**RE: Grading and Drainage Plan For Mesa Plaster Office (G15-D60) Dated May 31, 2001**

RE: MESA LATH & PLASTER (Aka: High Desert Roofing Office) (G-15/D60)  
(700 Industrial Rd NE )  
ENGINEERS CERTIFICATION FOR CERTIFICATE OF OCCUPANCY  
ENGINEERS STAMP DATED 5/31/2001 Rev. 2/7/2002  
ENGINEERS CERTIFICATION DATED 2/7/2002

RE: MESA LATH & PLASTER (Aka: High Desert Roofing Office) (G-15/D60)  
(700 Industrial Rd NE )  
ENGINEERS CERTIFICATION FOR CERTIFICATE OF OCCUPANCY  
ENGINEERS STAMP DATED 5/31/2001  
ENGINEERS CERTIFICATION DATED 1/29/2002

Grading & Drainage Plan

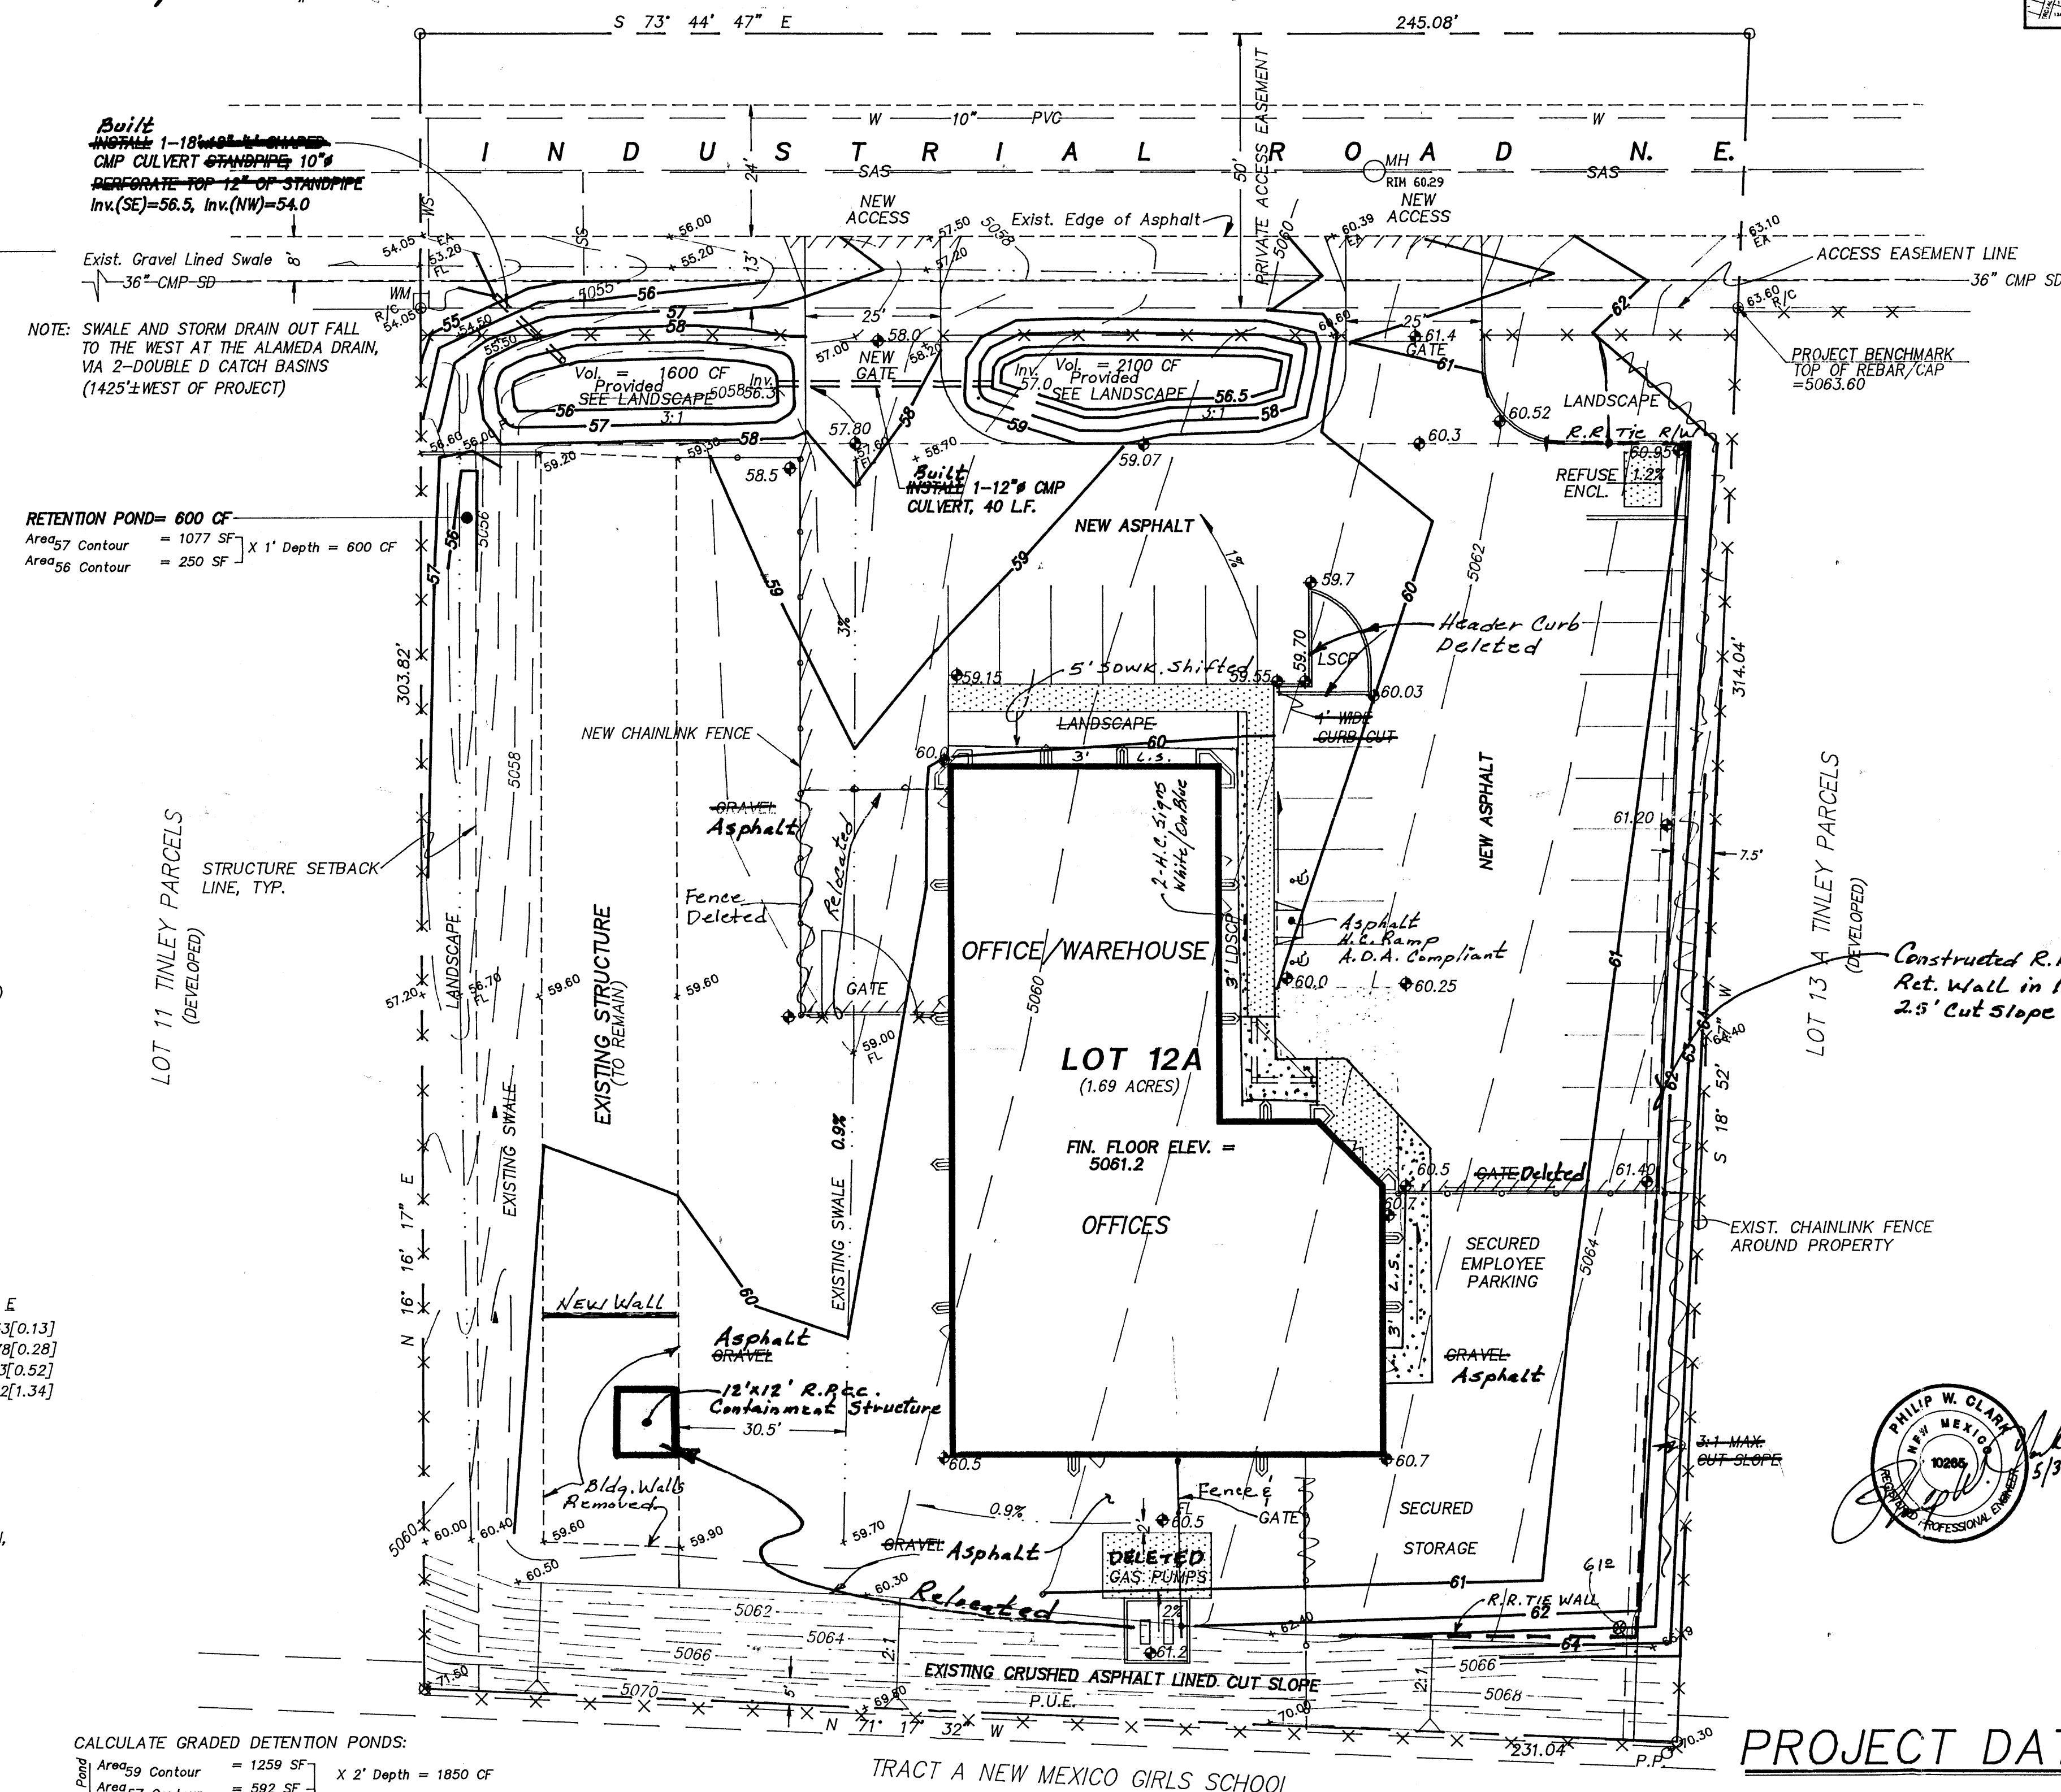
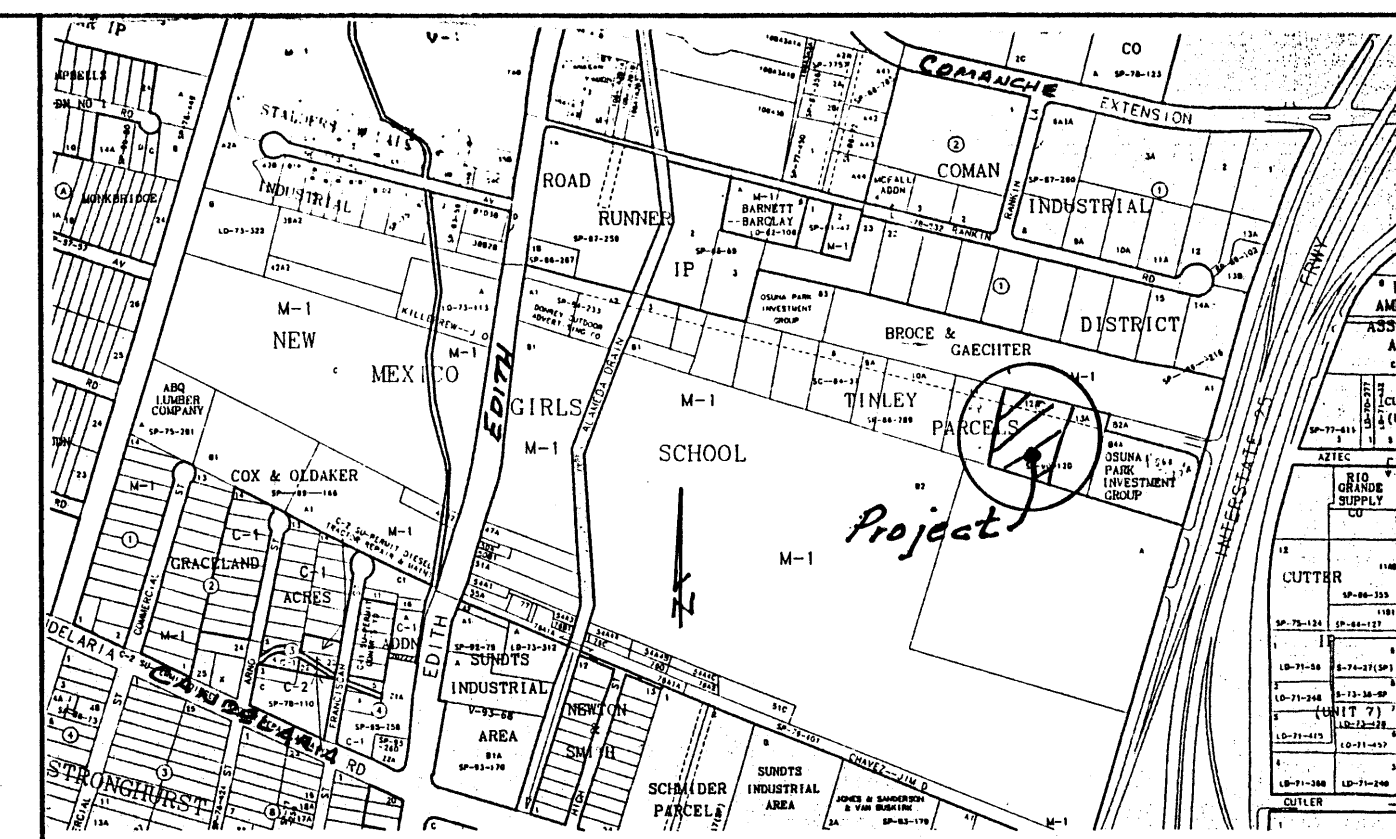
- Due to the change in paving material from gravel to asphalt for the parking lot, a new calculation for the detention ponds will be required. With the increased drainage runoff to the ponds, it will be necessary to show that the pond volume can hold the extra runoff.

Need to  
Refigure  
Pond Volume  
Increase Because  
of Gravel to  
Asphalt.
